Job: 160004
Maine Eye
Maine Eye Care

Spec Section No: 084523
Submittal No: 1
Revision No: 0
Sent Date: 7/20/2016

Submittal Title: Main Entrance Aluminum Canopy Design

DRAWN BY	DATE
MW	07/12/2016
CHKD. BY	DATE
DPL	07/19/2016
FILE NAME	
16025.dwg	
DWG. NO.	
S16-025	
SHEET 2 OF 4	
SHOP

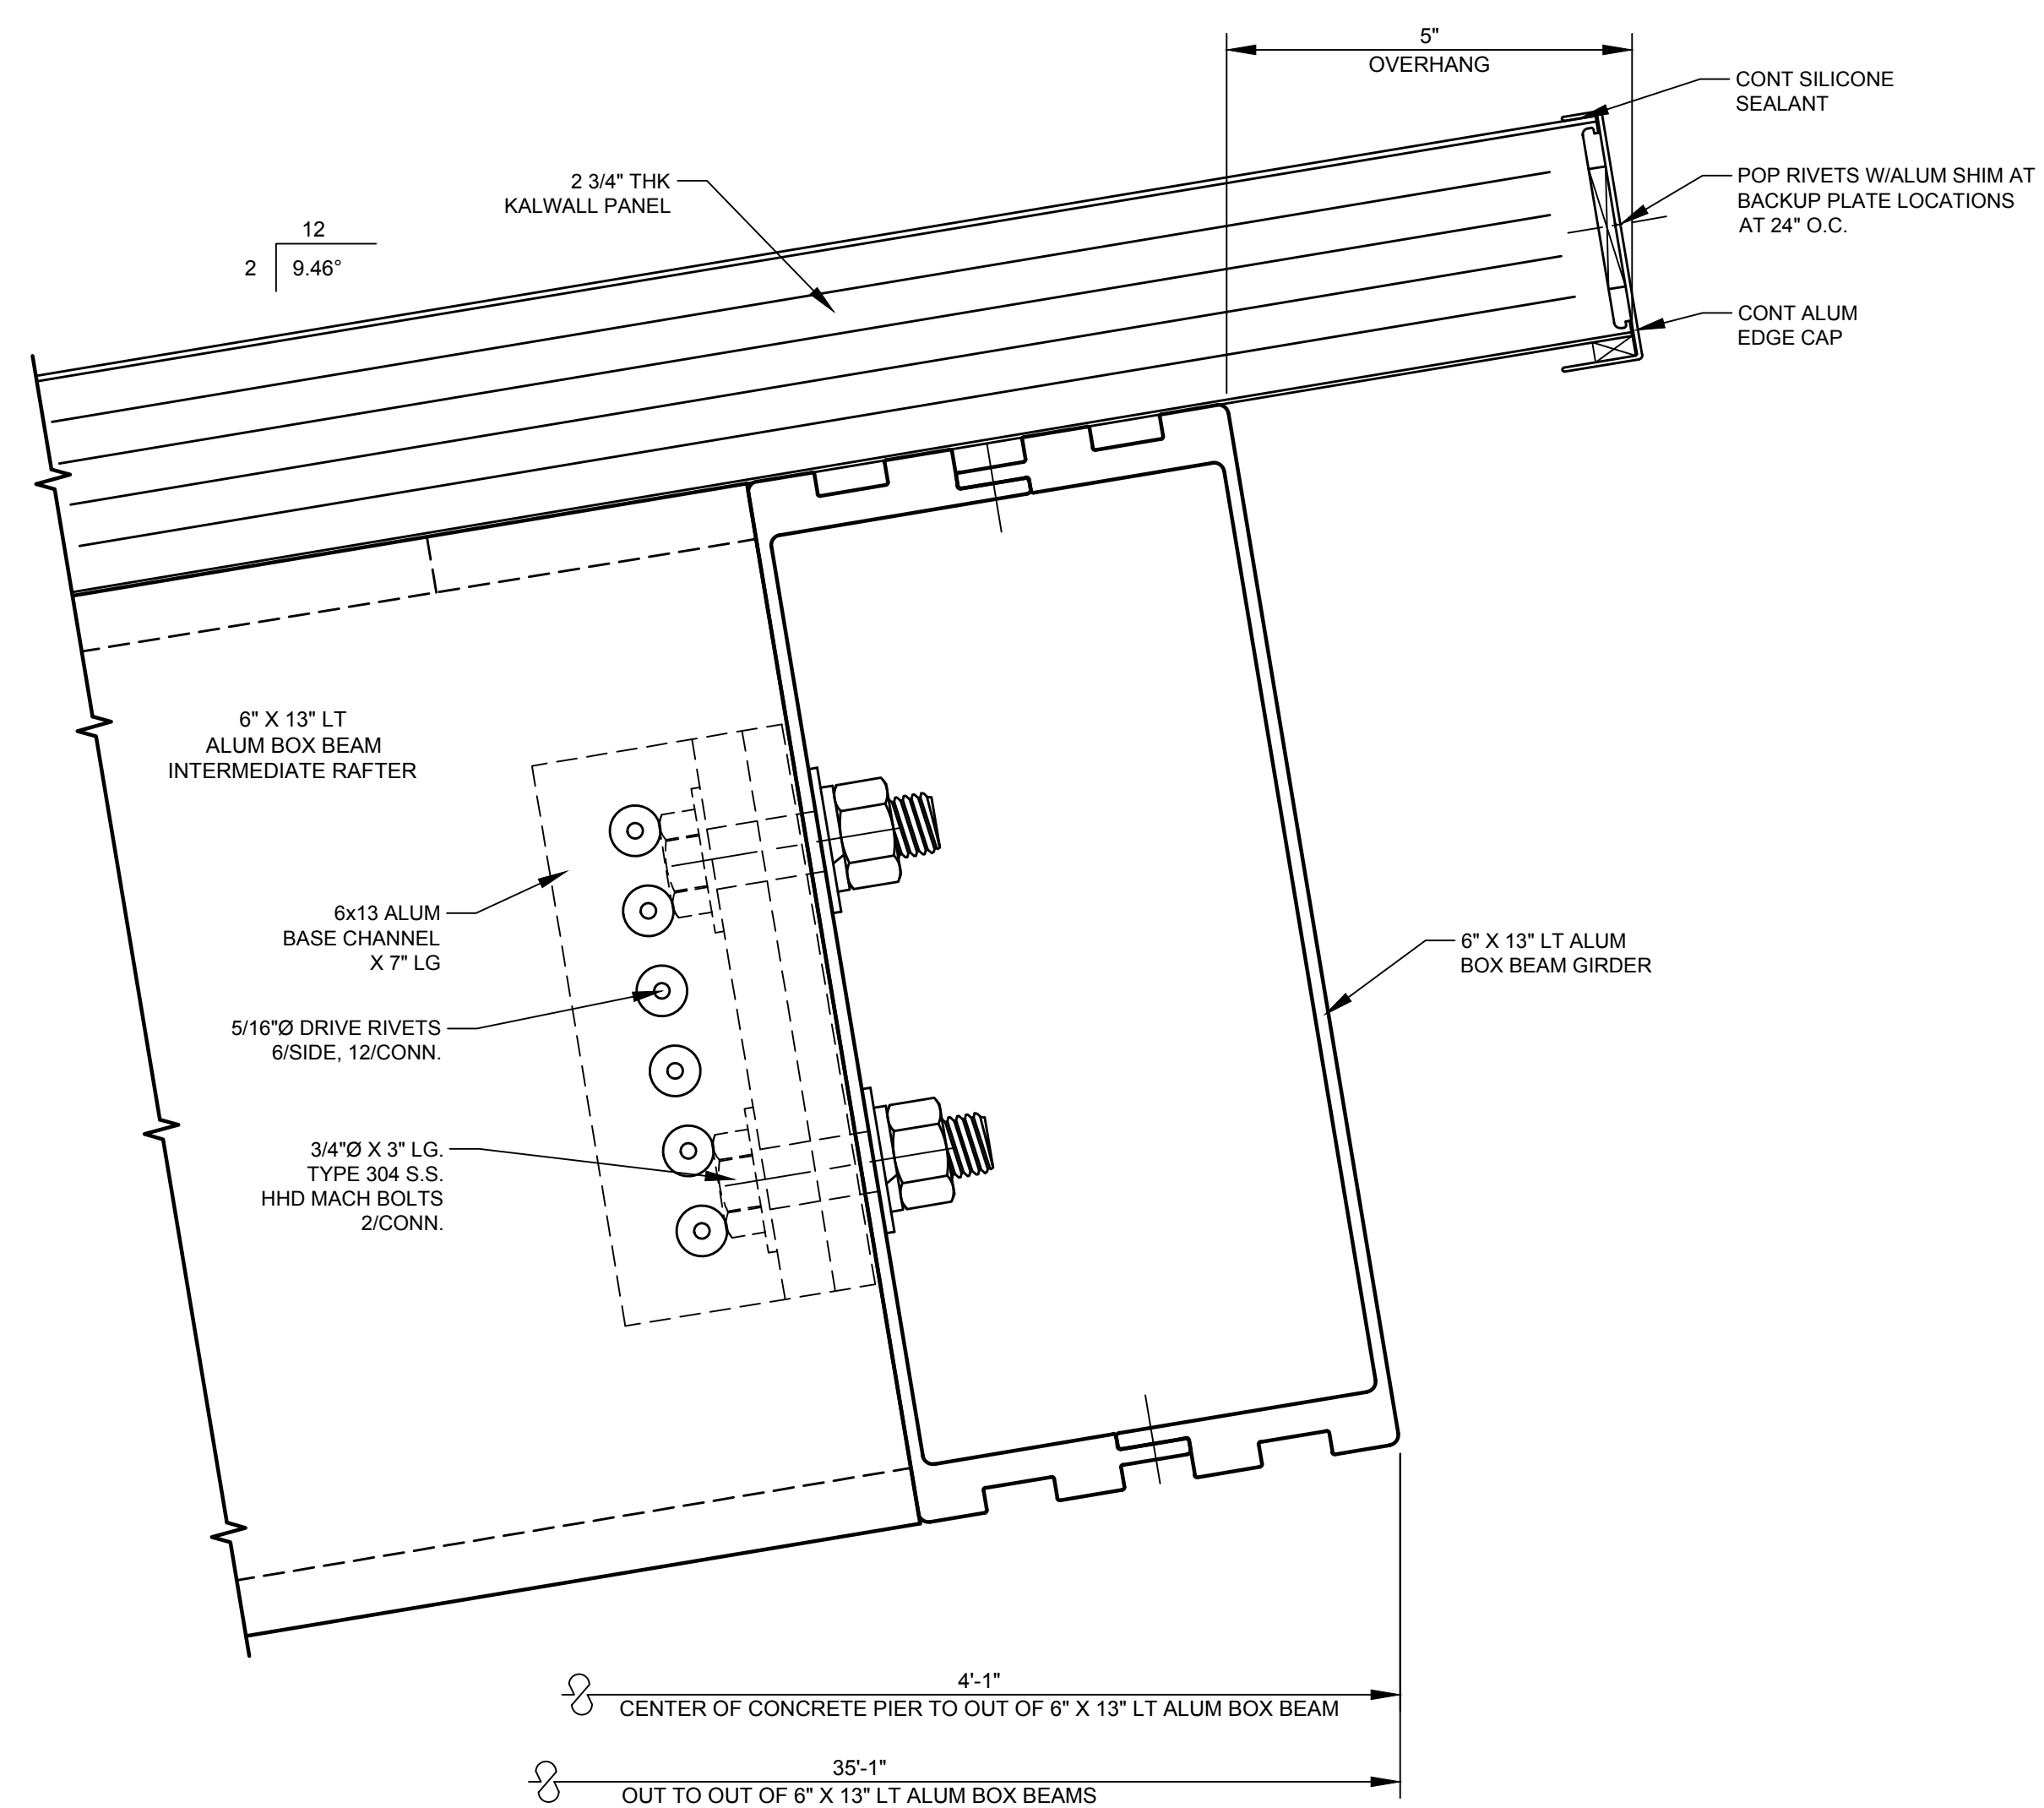
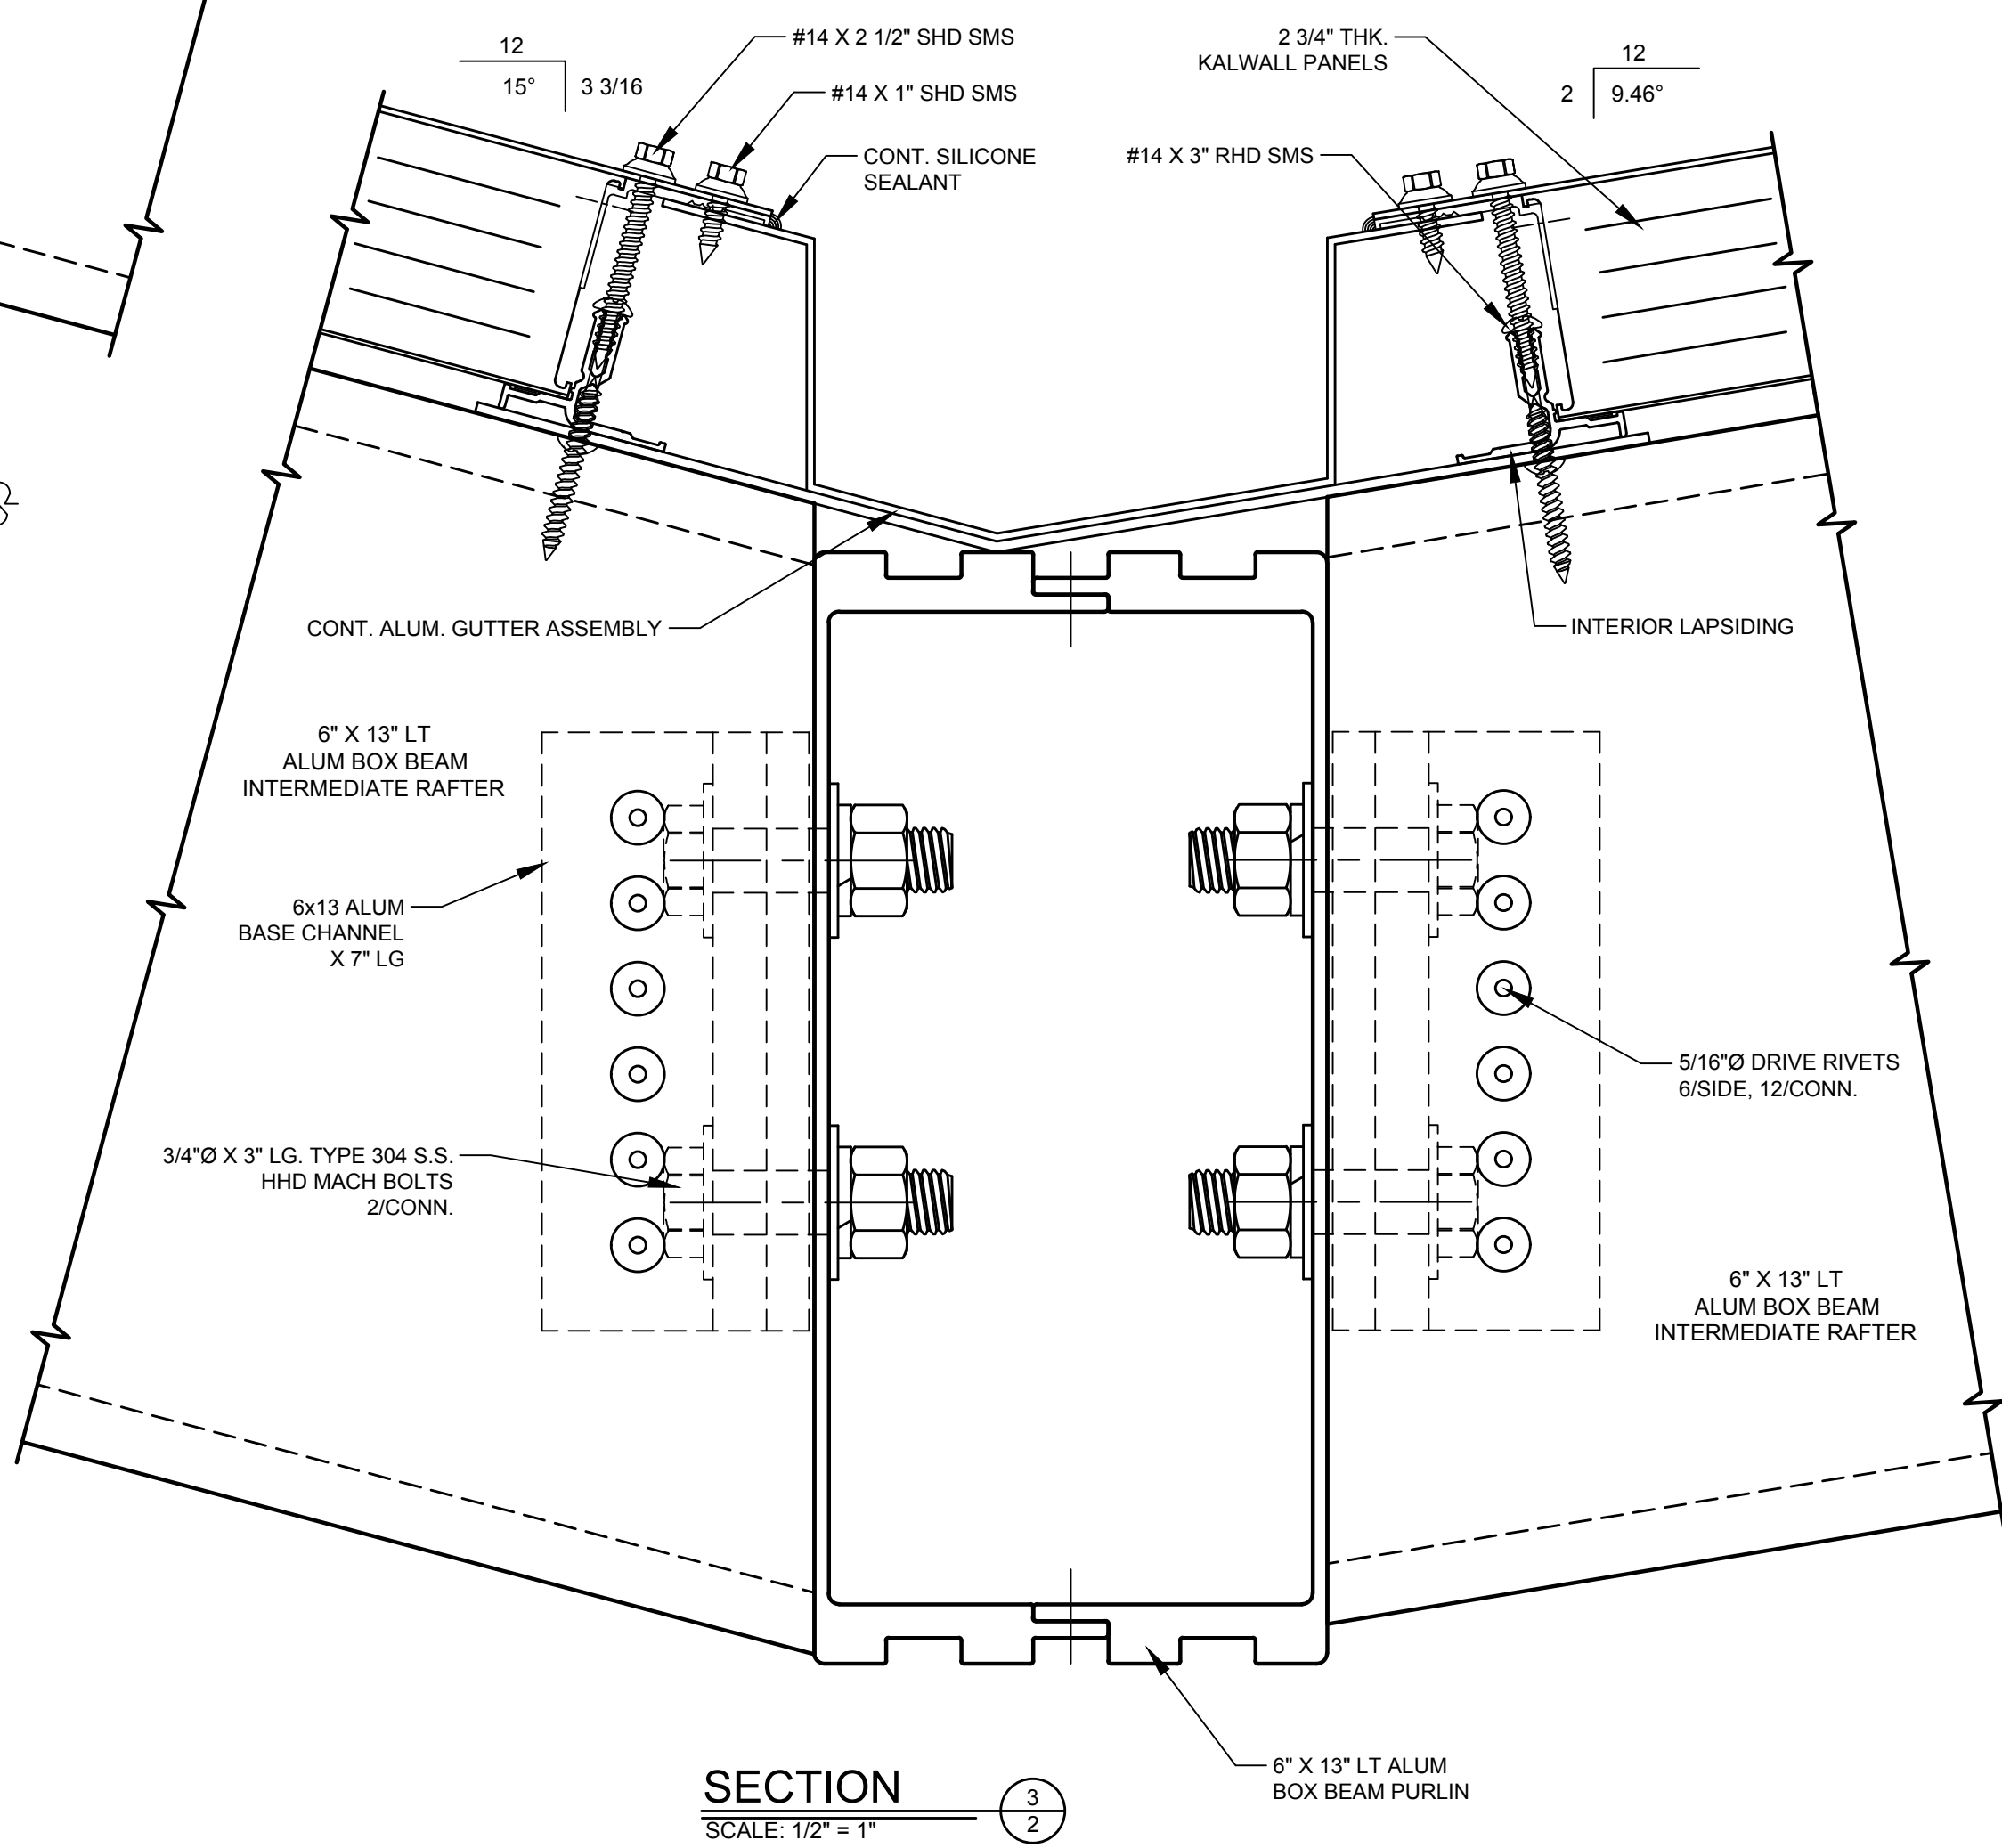
- 1. Architect to select color
 - 2. lead time is 10 weeks upon return
 - 3. Structures Unlimited to recognize
- conduit note on page 2 of this submittal and
provide hole or allow for one.
